Active
Travel
England

Your Ref: AL/11/24/OUT
Our Ref: ATE/24/00246/OUT
Date: 08 March 2024

Active Travel England Planning Response
Detailed Response to an Application for Planning Permission

Site Address: LAND TO EAST OF, WESTERGATE STREET,
WESTERGATE, PO20 3XL

PROJECT: SITE ACCESS GENERAL ARRANGEMENT

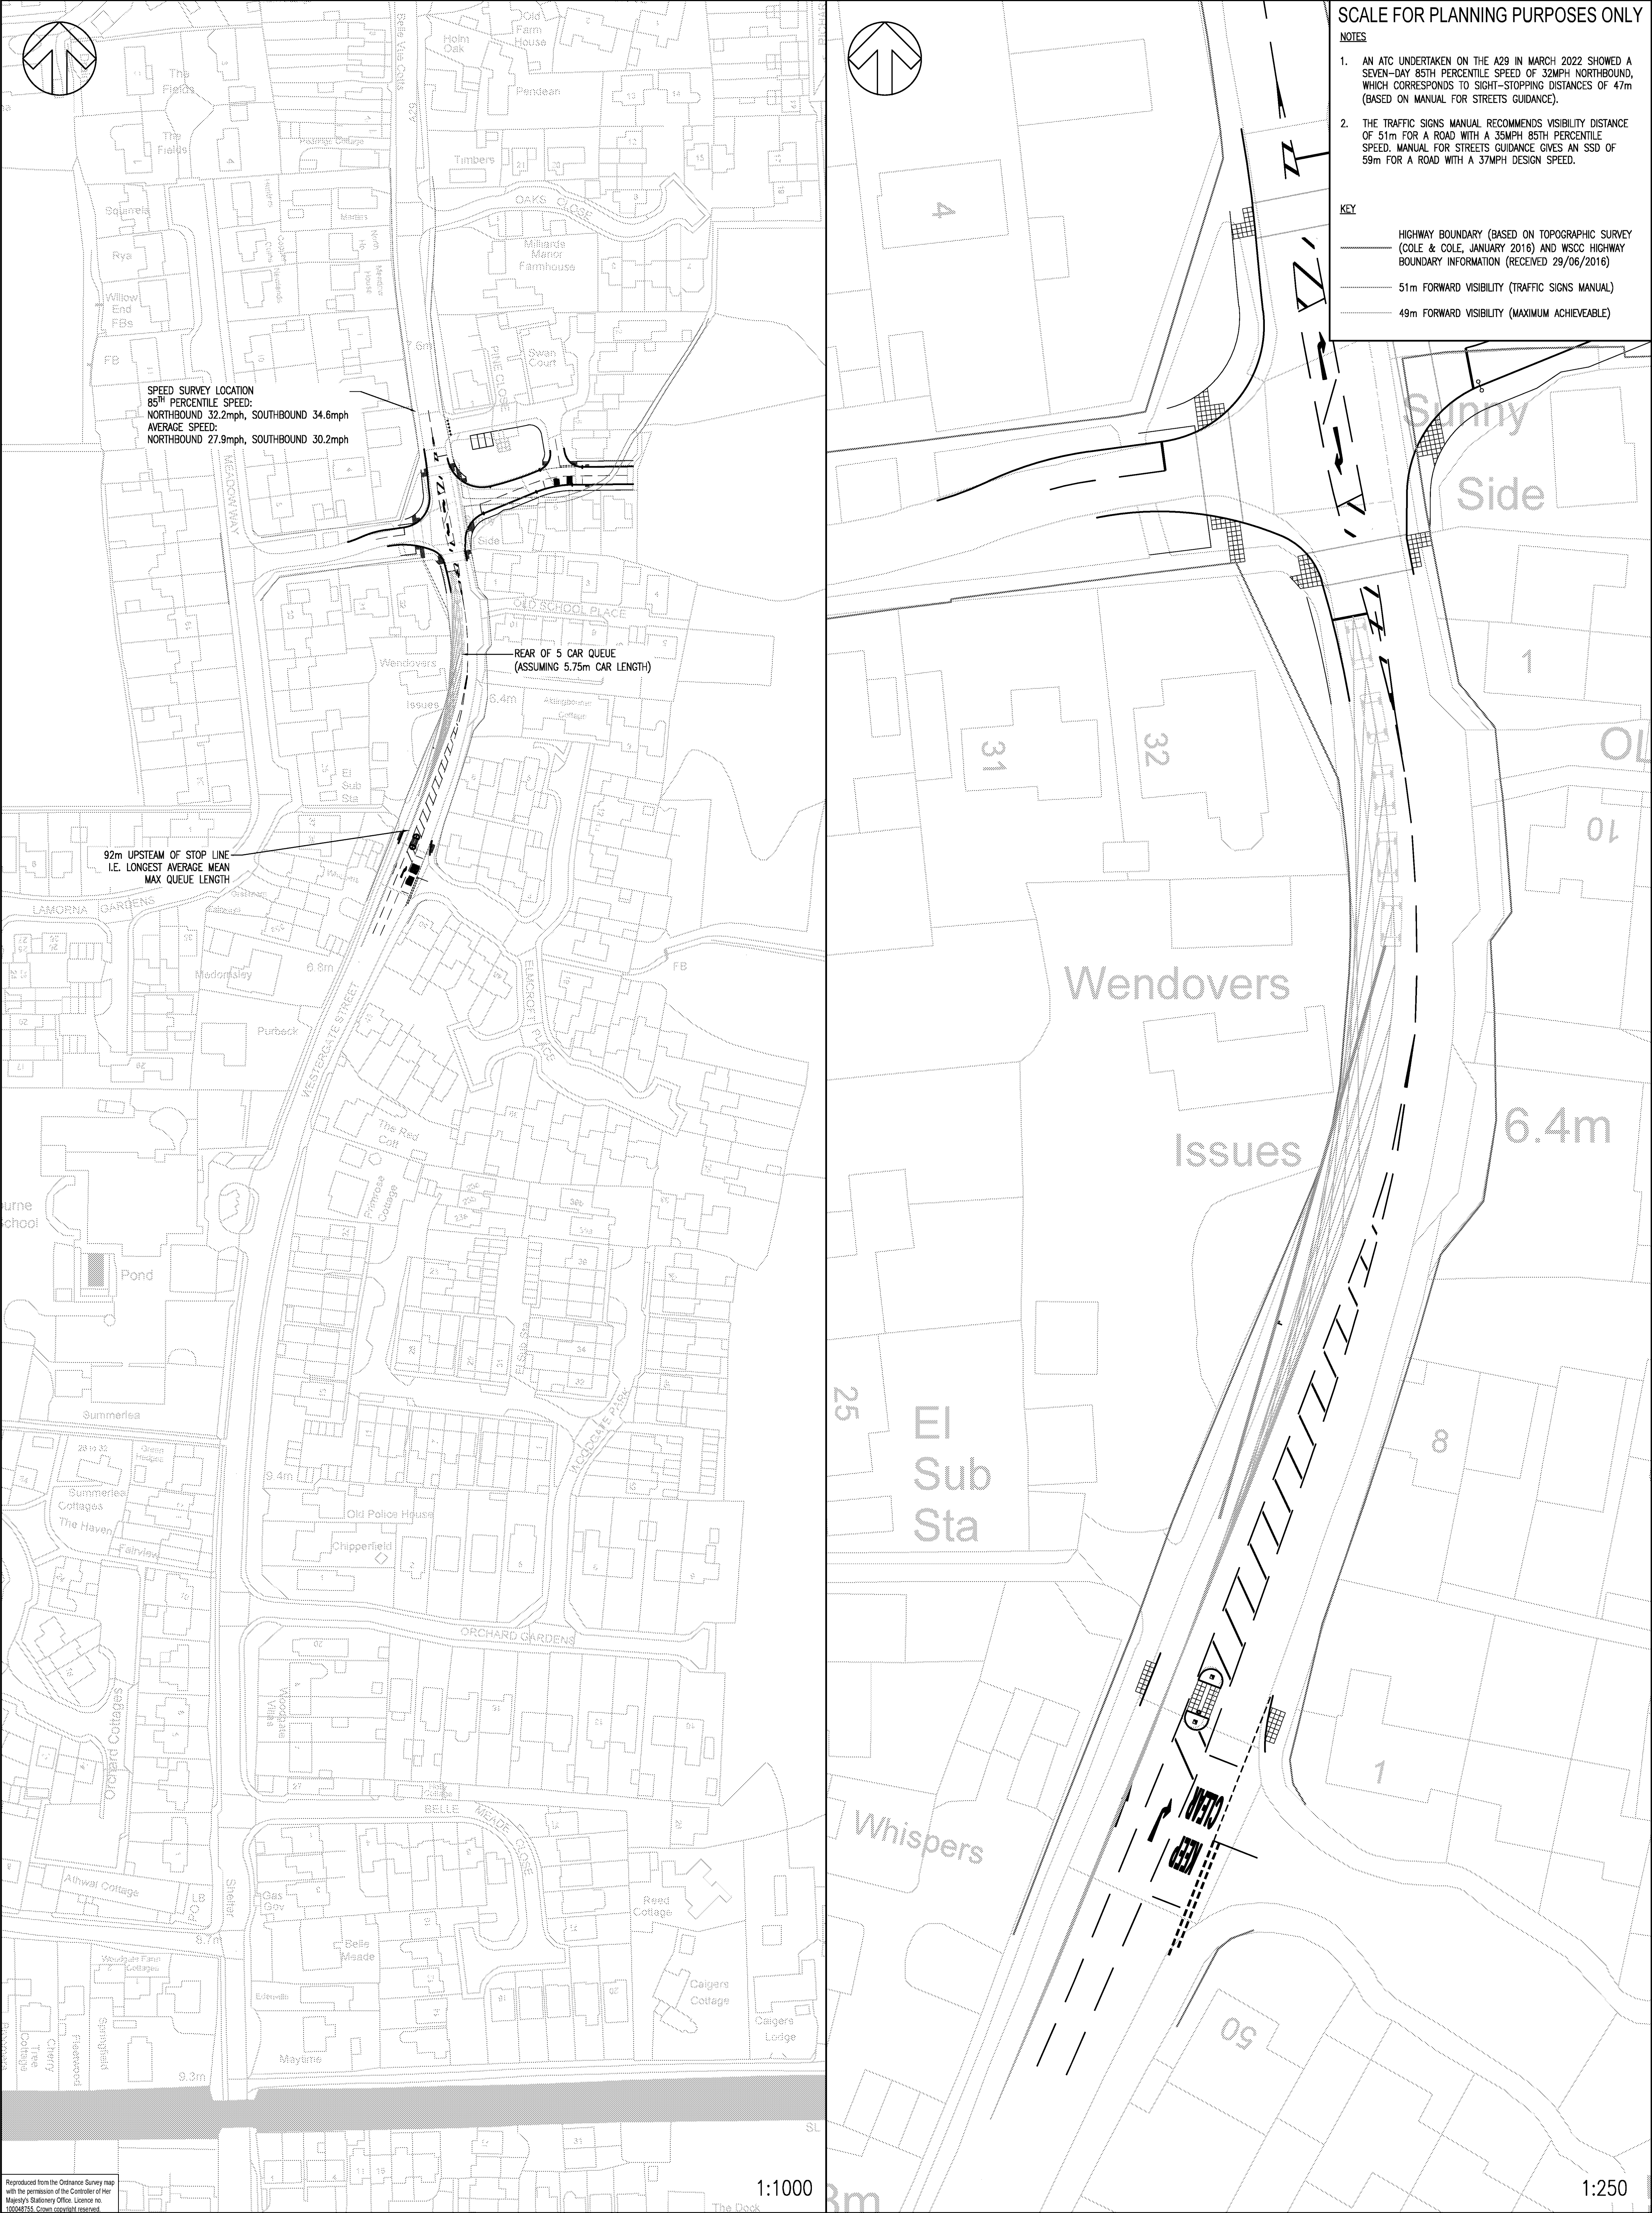
(a) To ensure that the crossings/amenities at the main access point (as per the site access drawings in Appendix II of the submitted TA) are applicable for all active travel users, and also adhere to the Junction Assessment Tool (JAT) included in LTN 1/20.
